Greater
Hume
Council

Greater Hume Council Endorsed Submission to the Environmental Impact Statement (EIS) – Jindera Solar Farm

8 November 2019

Figure 1: Land and Soil Capability Mapping

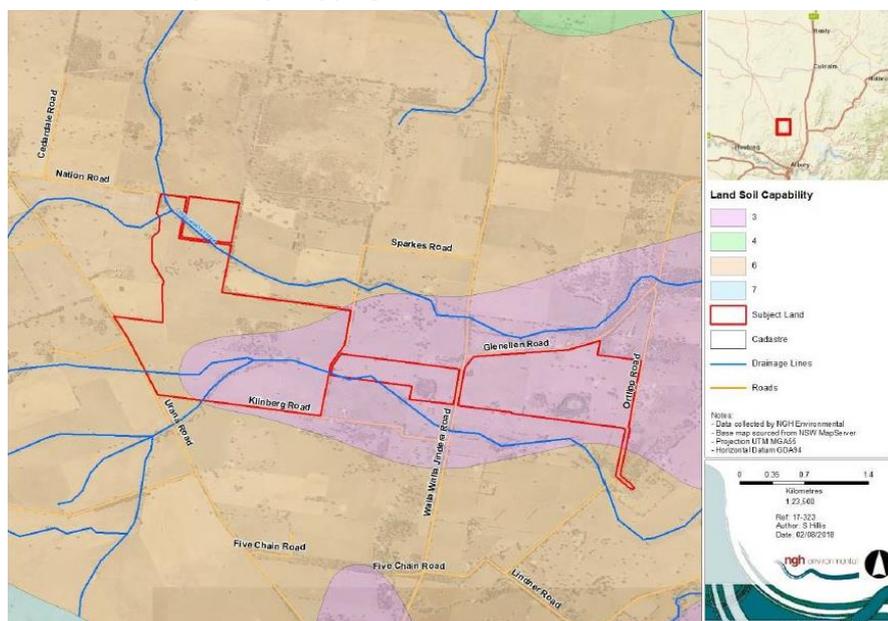
The EIS indicates that the land on which the subject development is classified as class 3 land and class 6 under the Land and Soil Capability Assessment Scheme. Perusal of Figure 6.13 in the EIS and Figures 3.9 and Figures 3.10 reveals that a large majority of the development footprint is situated on the Class 3 High Capability Land rather than the Class 6 Low Capability Land. It is noted that DPI Agriculture commented through the

SEARS that *“the class 3 land should be protected as much as possible. The proponent should consider moving as much of the development from the Class 3 land (as assessed under the Land and Soil Capability Scheme to the class 6 lands that surround the site. This land (class 3) is considered as High Capability Land as outlined in the Preliminary Environmental Assessment, and aerial imagery shows that this land has been deep ripped in the past and has been actively used for cropping.”*

Consequently, as this site is important agricultural land and contains soils classed as capability class 3, the site should be considered constrained under the Department of Planning, Industry and Environments Large Solar Energy Guidelines.
